From: Iqraa Malik
Sent: 04 March 2022
To: Sian Eggington
Subject: FV WA/26/22/HH Kelsey Eastergate Lane

From: hda projects
Sent: 04 March 2022
To: ADC Planning
Cc: Iqraa Malik
Subject: RE: Request for further information WA/26/22/HH

WA/26/22/HH Kelsey Eastergate Lane

Title
Elevations as Proposed

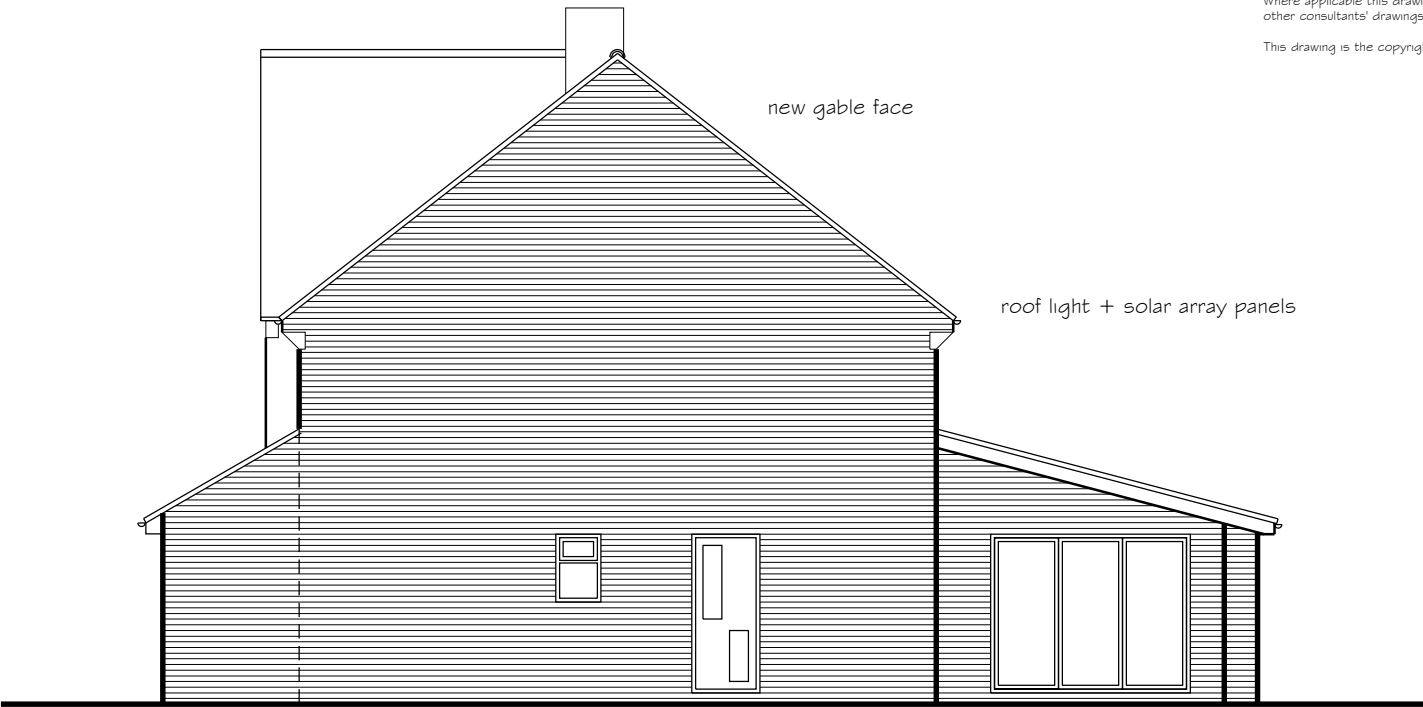
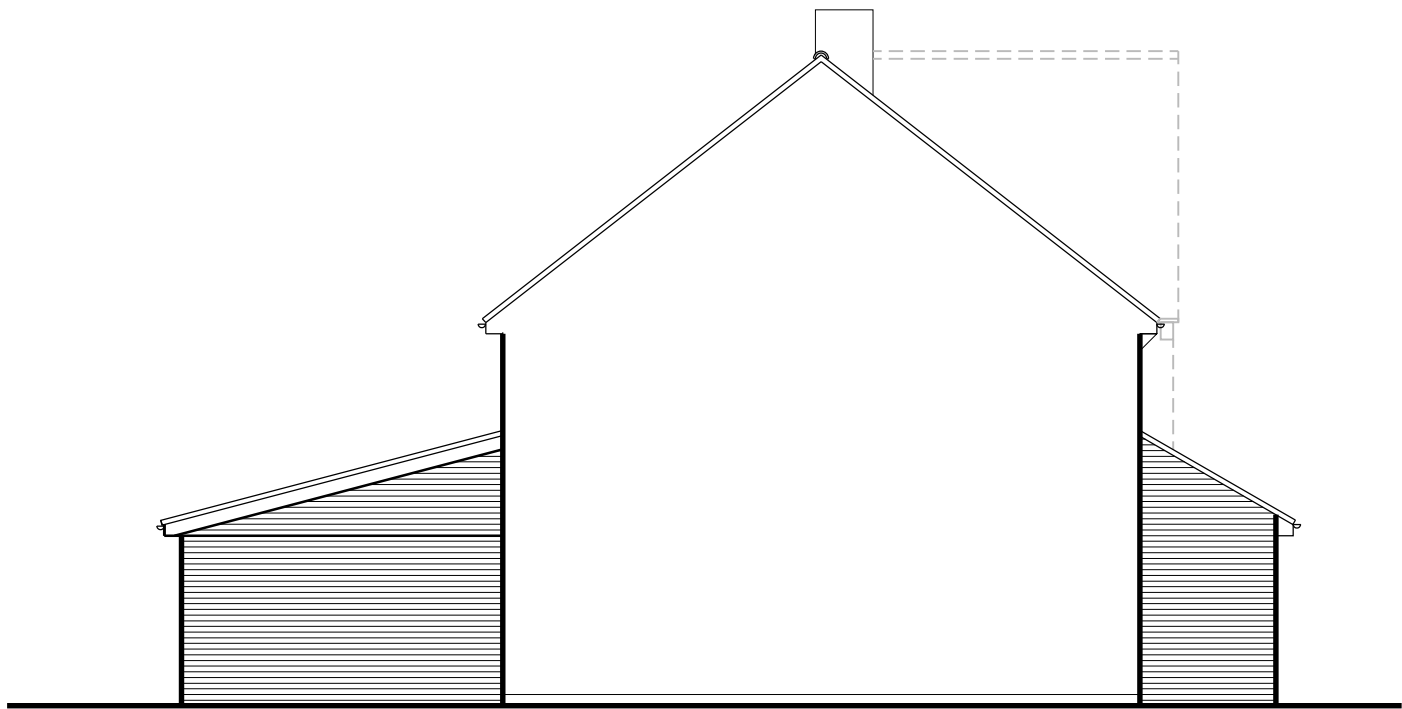
Further to your request, can we clarify that the existing garage will be removed and replaced with the two storey side extension and not converted. Please amend to suit.
